# Meeting Notes

Re: U-2509AB Concurrence Point 4B Meeting Minutes

J.R. Hopson opened the technical portion of the meeting by providing an overview of the natural resources in the general vicinity of the project to the merger team. He then provided a summary of the hydraulic avoidance and minimization efforts as well as stormwater treatment practices for the project. Following the overview, the preliminary drainage design plans were reviewed, sheet by sheet, and the following outlines the discussions held on each sheet:

PROJECT REFERENCE NO. U-2509AB	SHEET NO. 06
RW SHEET NO.	
ROADWAY DESIGN ENGINEER	HYDRAULICS ENGINEER
INCOMPLETE PLANS DO NOT USE FOR R/W ACQUISITION	
DOCUMENT NOT CONSIDERED FINAL UNLESS ALL SIGNATURES COMPLETED

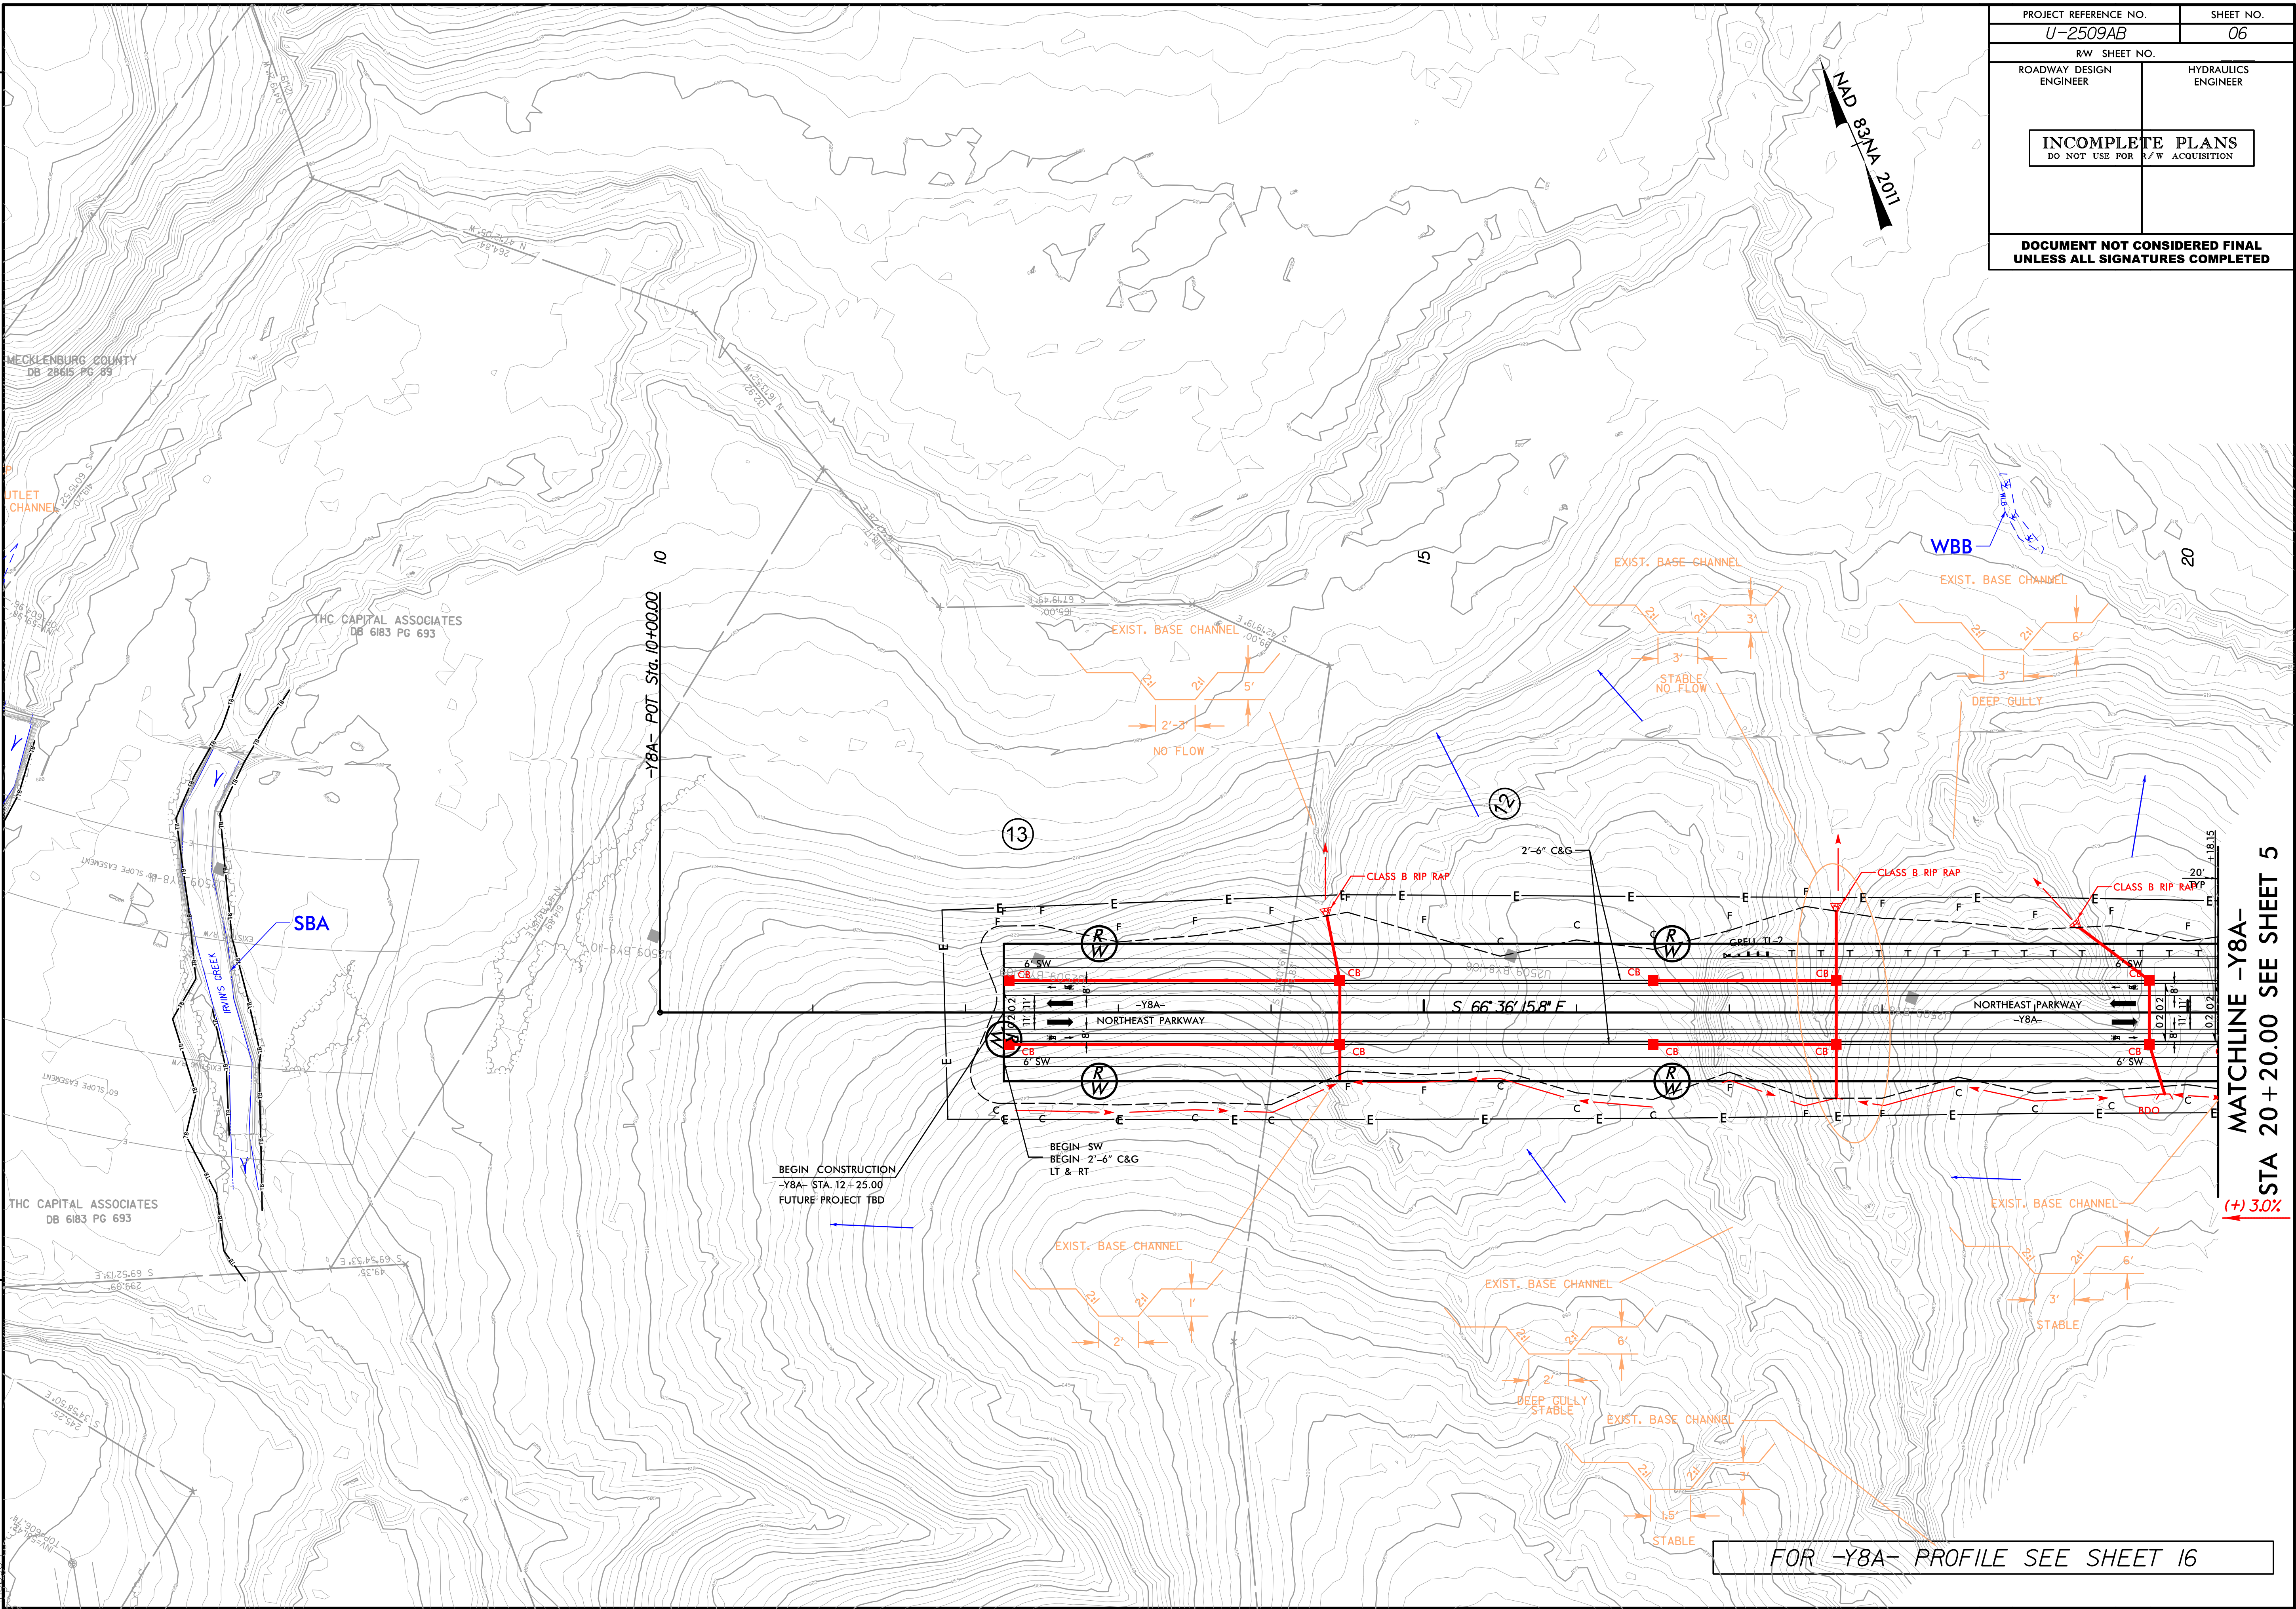
- Susan Locklear asked VHB to consider outletting roadway drainage into berm ditch to save on pipe & allow more vegetated conveyance. After considering this potential design alternative, it was determined that the current alignment be retained as piping into a berm ditch would not be feasible.

PROJECT REFERENCE NO. U-2509AB	SHEET NO. 07
RW SHEET NO.	
ROADWAY DESIGN ENGINEER	HYDRAULICS ENGINEER
INCOMPLETE PLANS DO NOT USE FOR R/W ACQUISITION	
DOCUMENT NOT CONSIDERED FINAL UNLESS ALL SIGNATURES COMPLETED

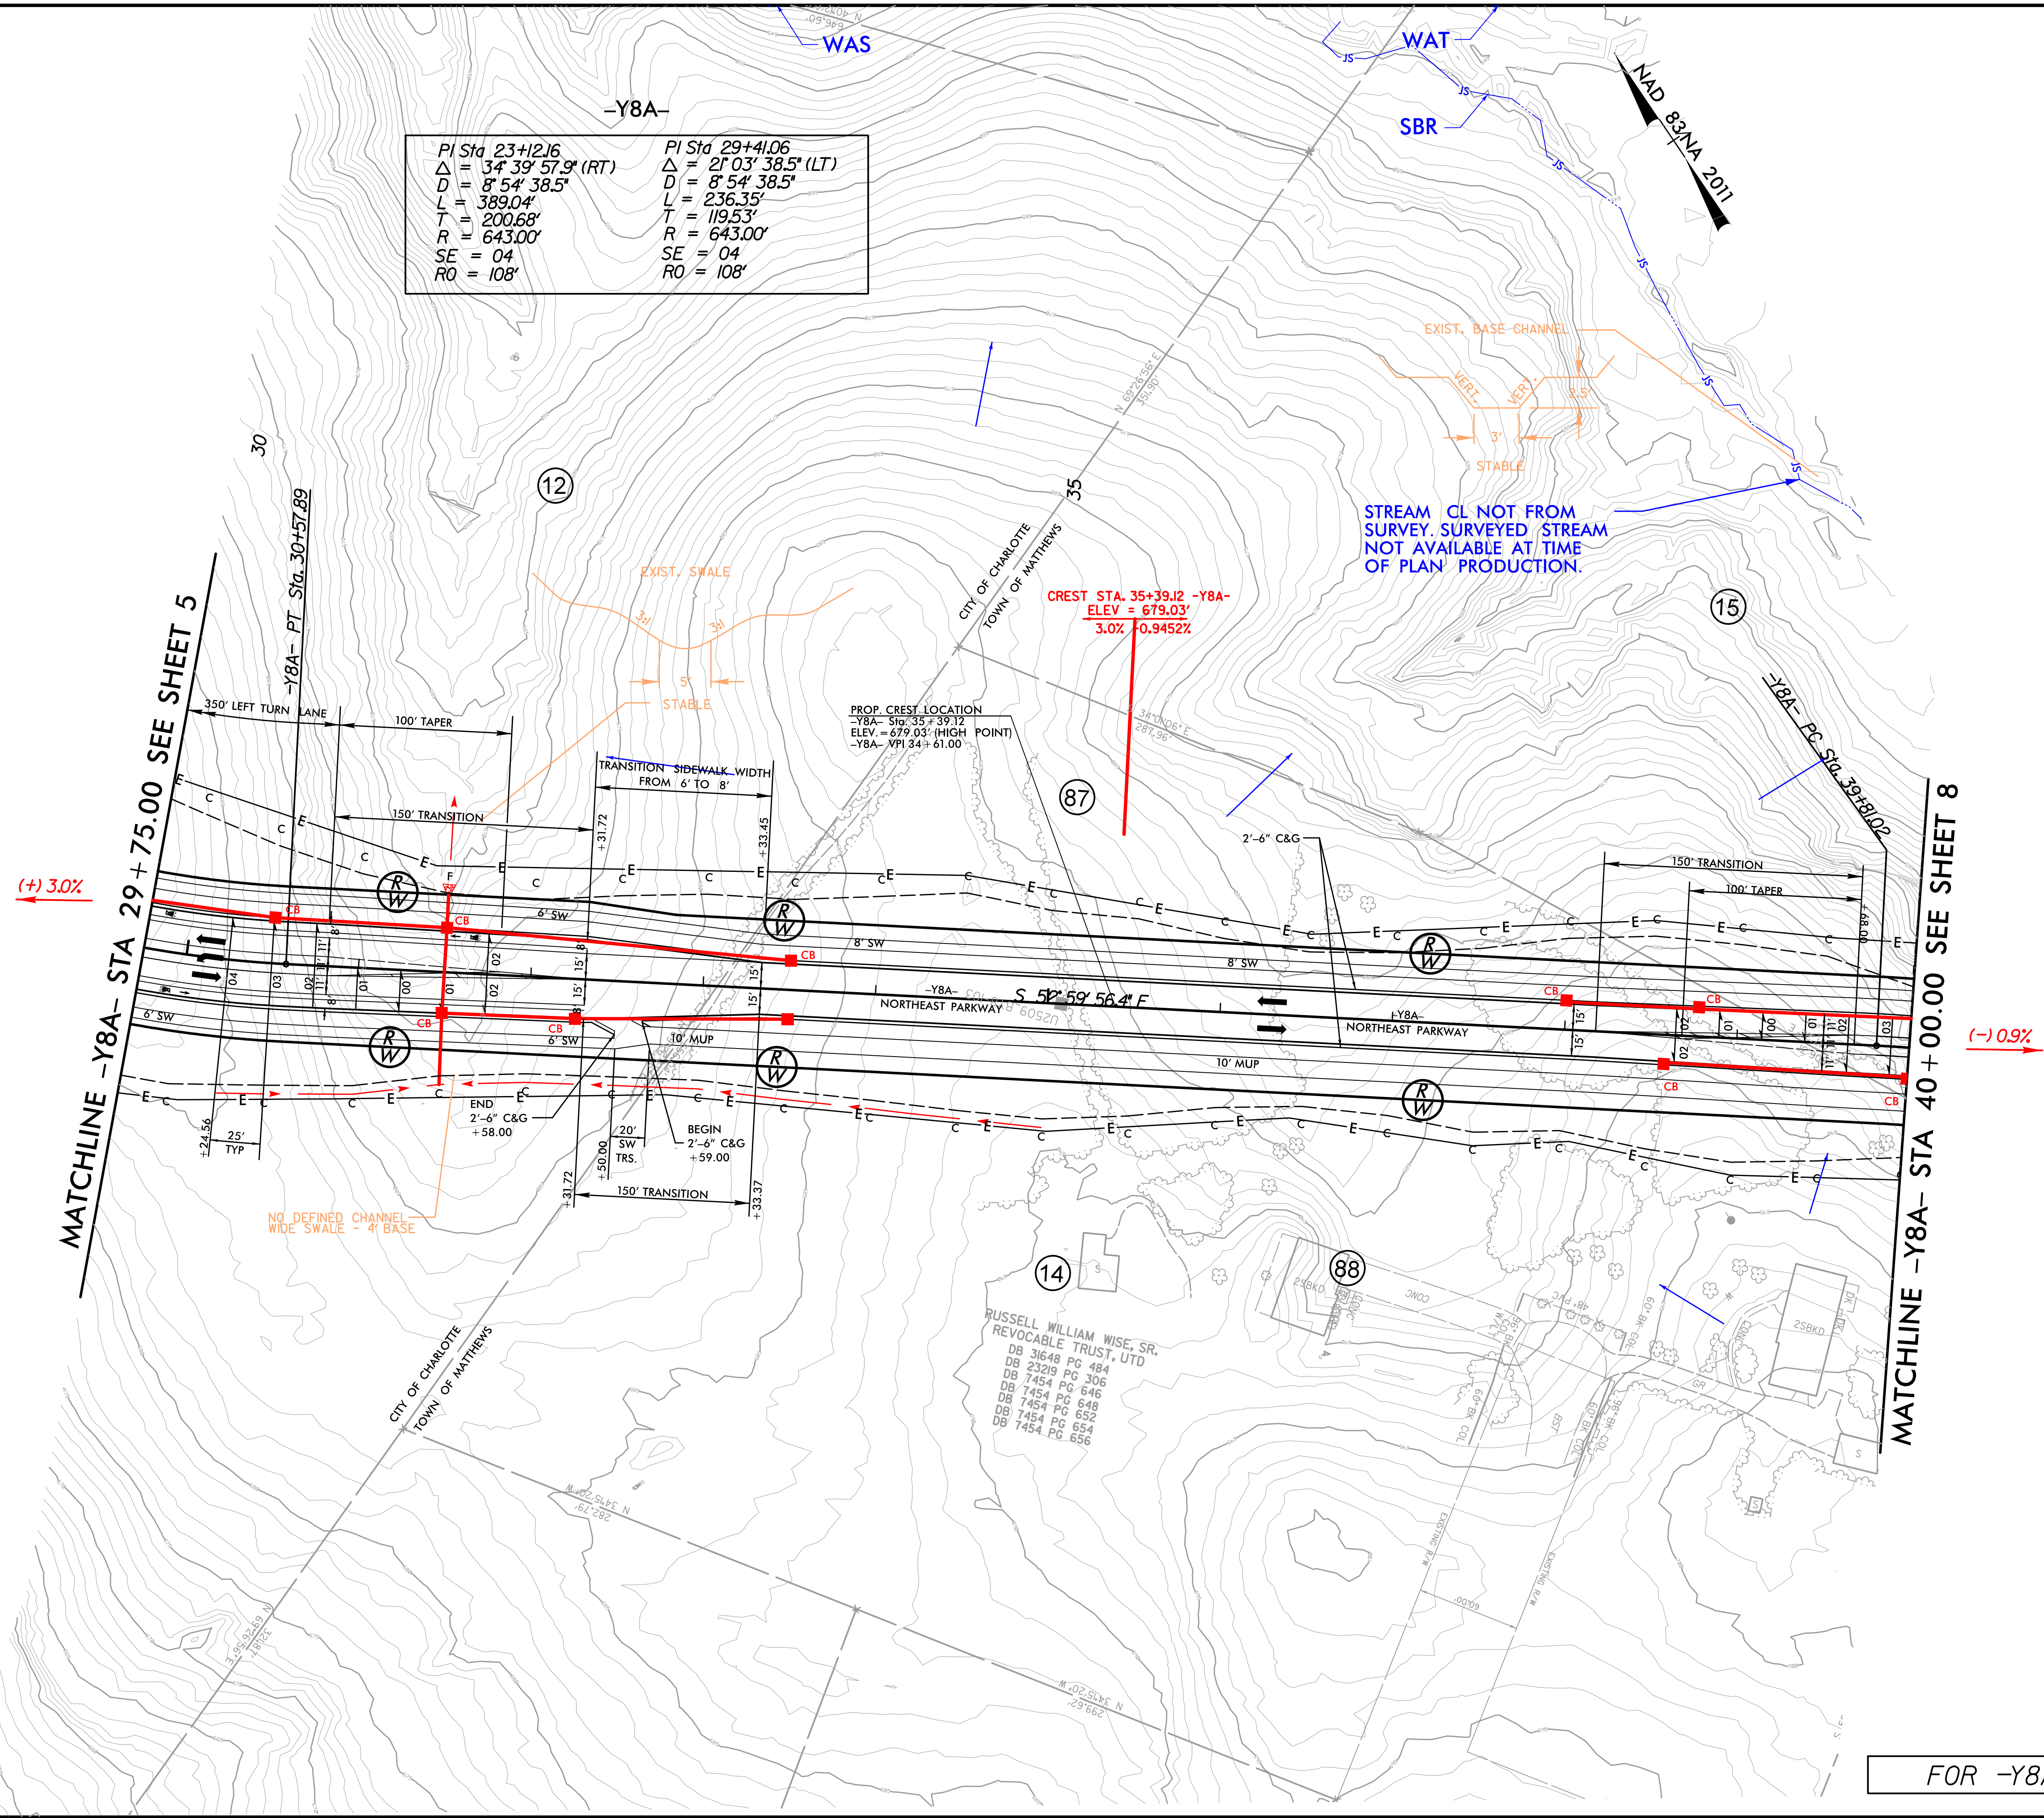
- Susan Locklear asked VHB to consider outletting roadway drainage into berm ditch to save on pipe & allow more vegetated conveyance. After considering this potential design alternative, it was determined that the current alignment be retained as piping into a berm ditch would not be feasible.
